STATE OF NORTH CAROLINA
DEPARTMENT OF TRANSPORTATION

Addendum No. 1

RE: Contract ID C203050

Bascule Span of Bridge #110 On The Carolina Coastal Railroad
Over the Newport River

STATE OF NORTH CAROLINA
 DEPARTMENT OF TRANSPORTATION
 RALEIGH
 GENERAL NOTES FOR
 REMOTE CONTROL
 STATION &
 CONTROL BUILDING

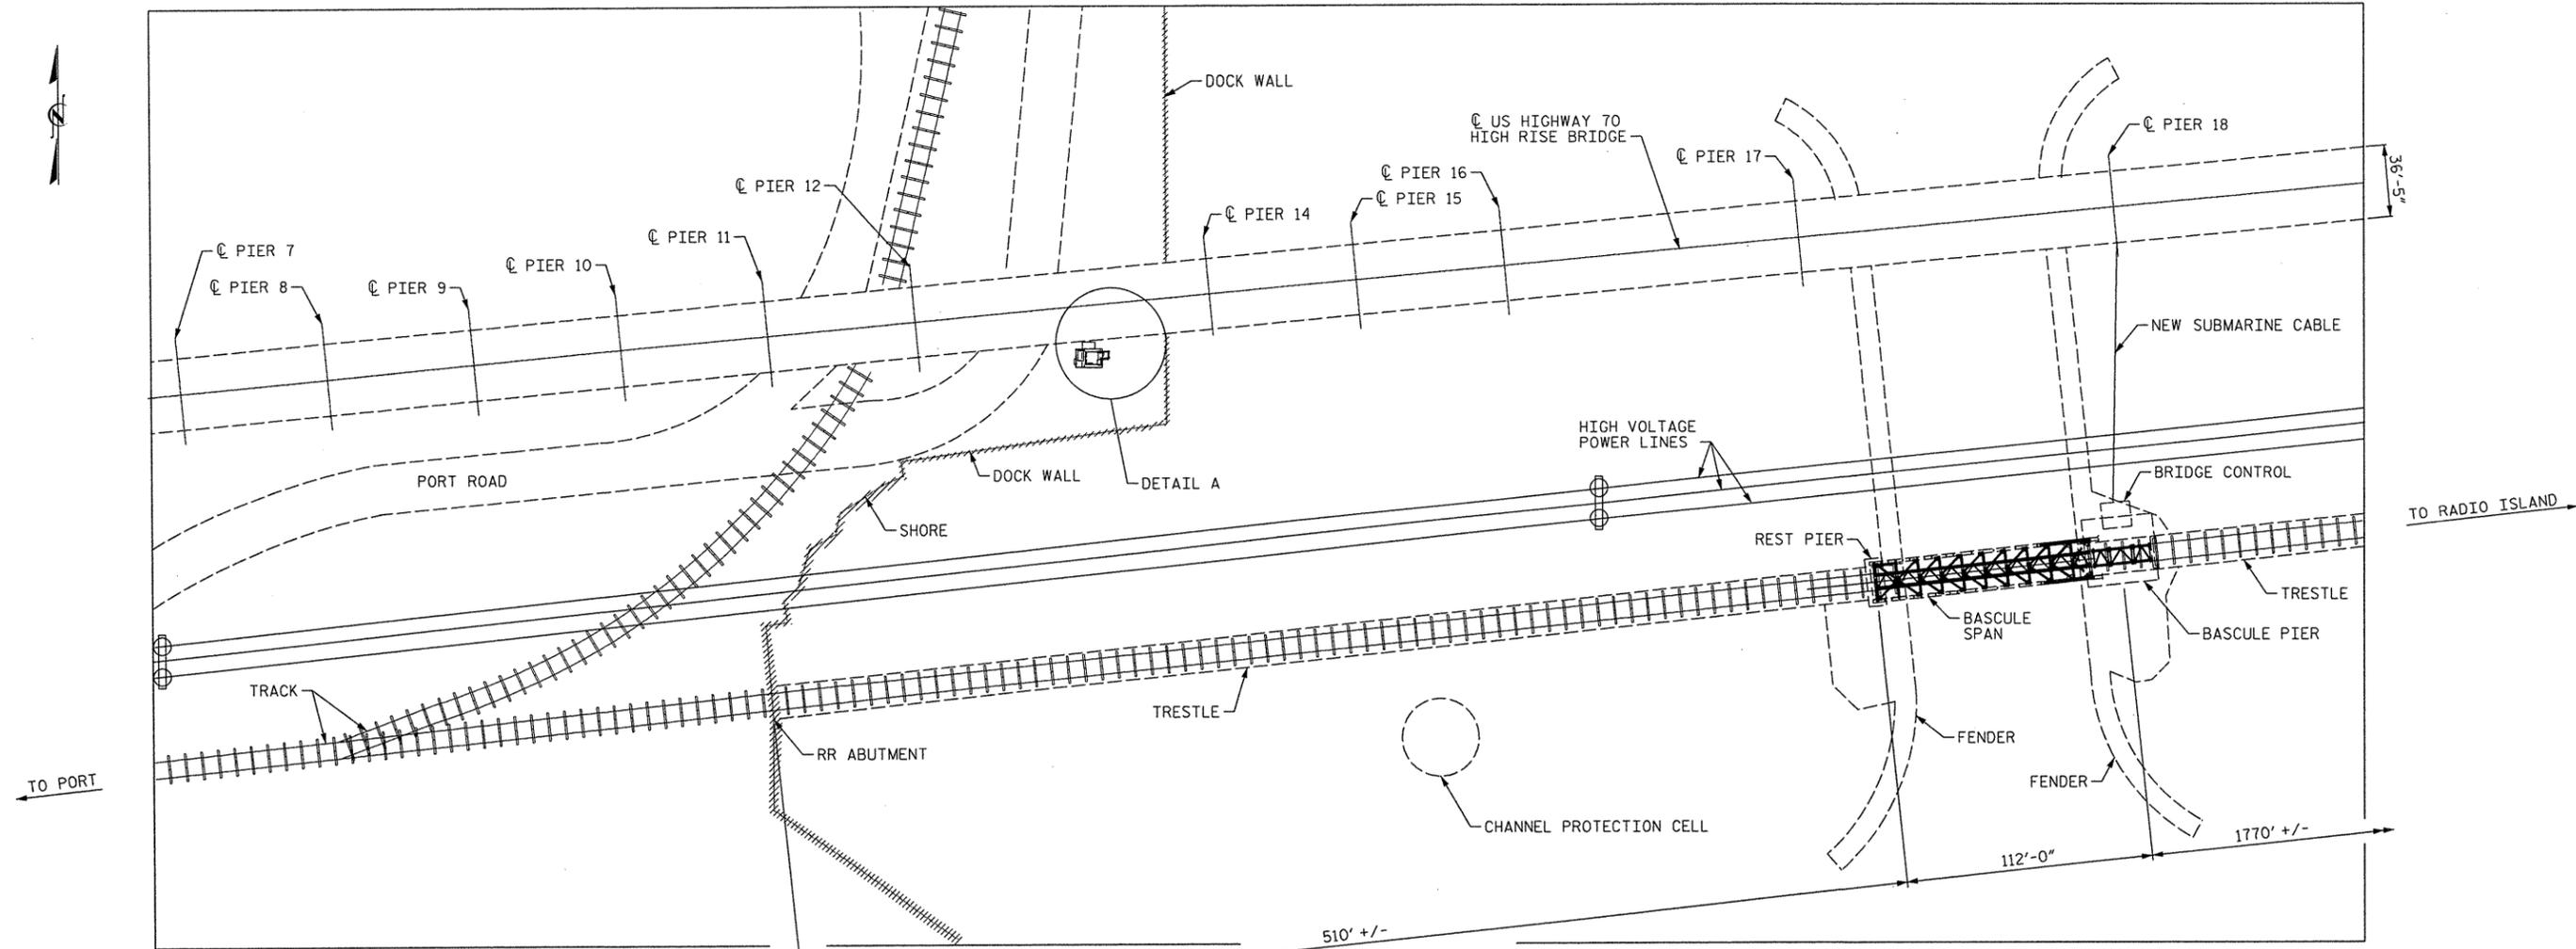
On Sheet No. G-05 the notes have been revised to clarify that the Control House work is included in the Bridge Electrical work. Please void Sheet No. G-05 in your plans and staple the revised Sheet No. G-05 thereto.

3/19/2012 3:36:41 PM N:\p\o\dev\ncd001\Radio Island\CAD\STRUCTURAL\S-26 BASC GRDR REIN.dgn

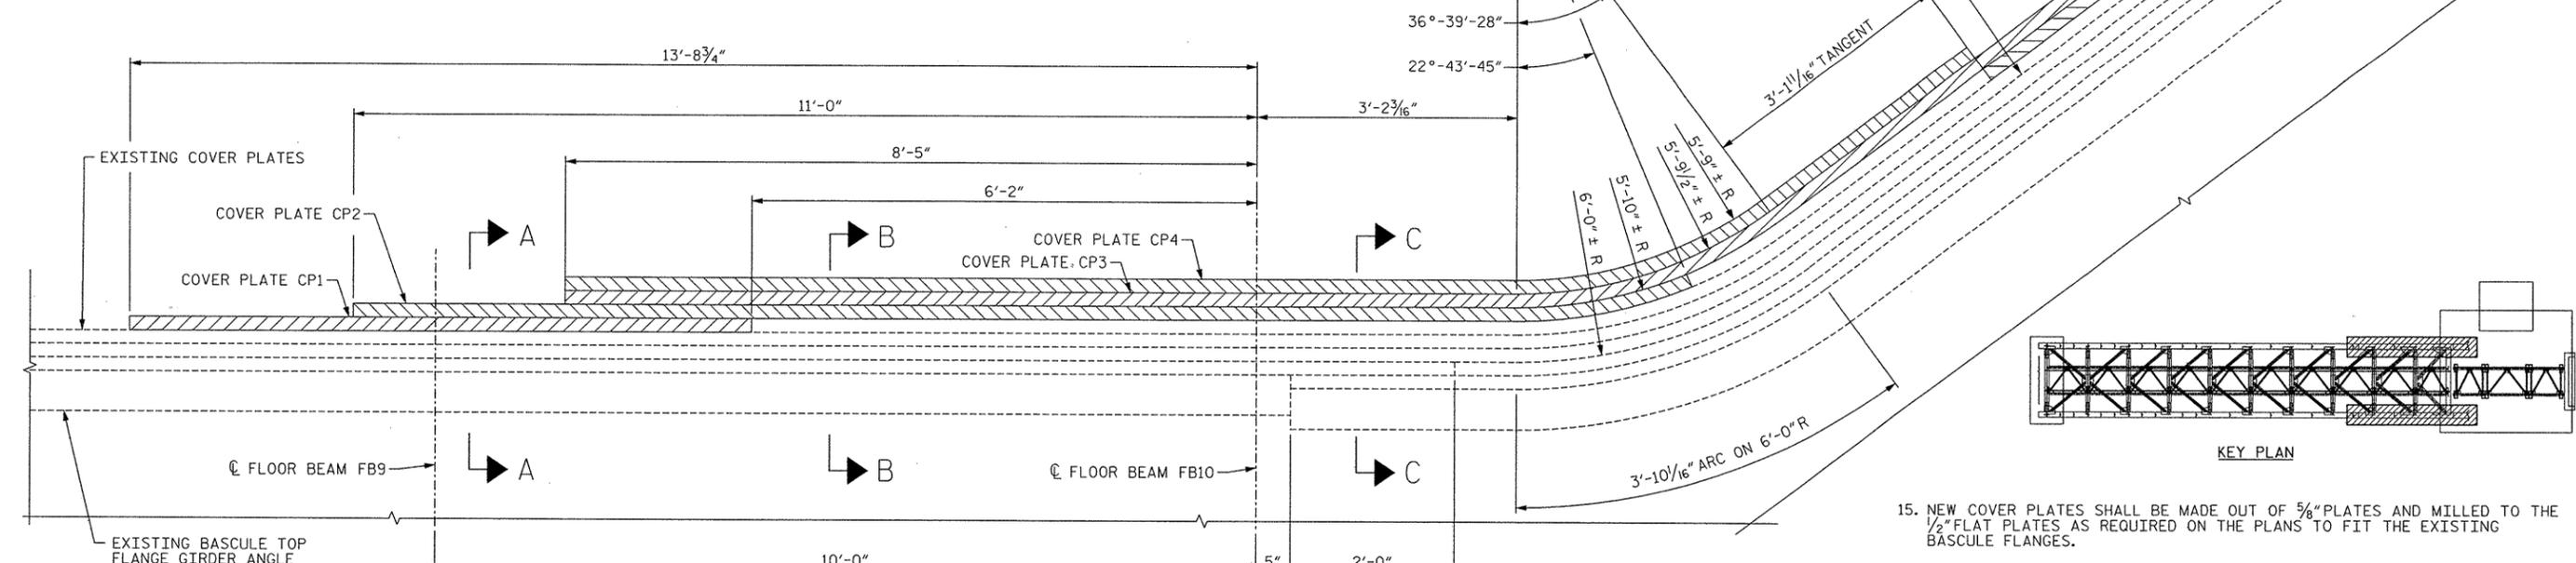
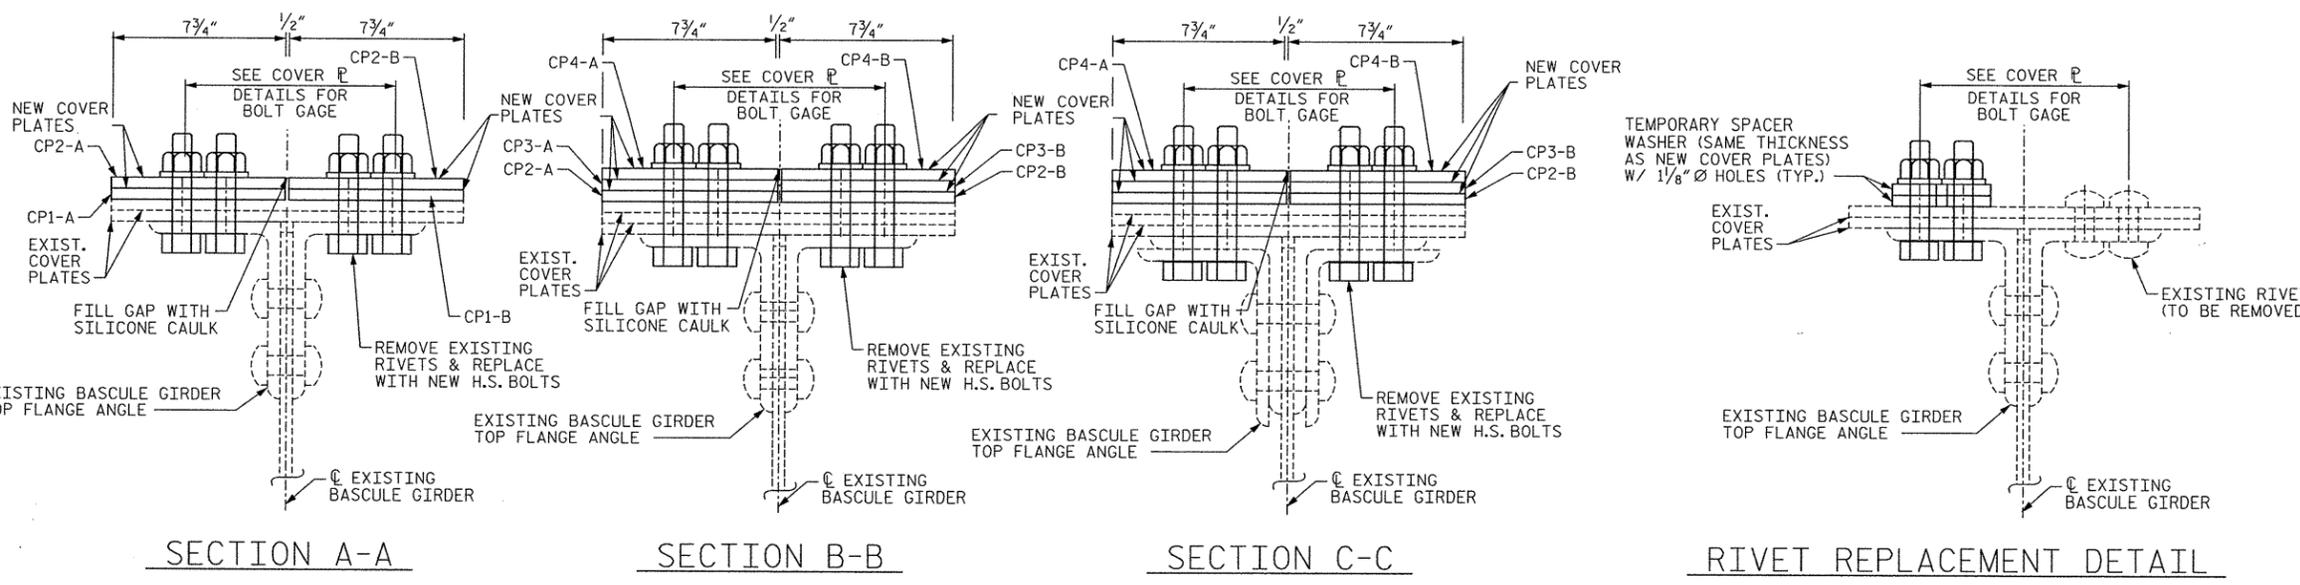
On Sheet No. S-26 the cover plate reference has been corrected. Please void Sheet No. S-26 in your plans and staple the revised Sheet No. S-26 thereto.
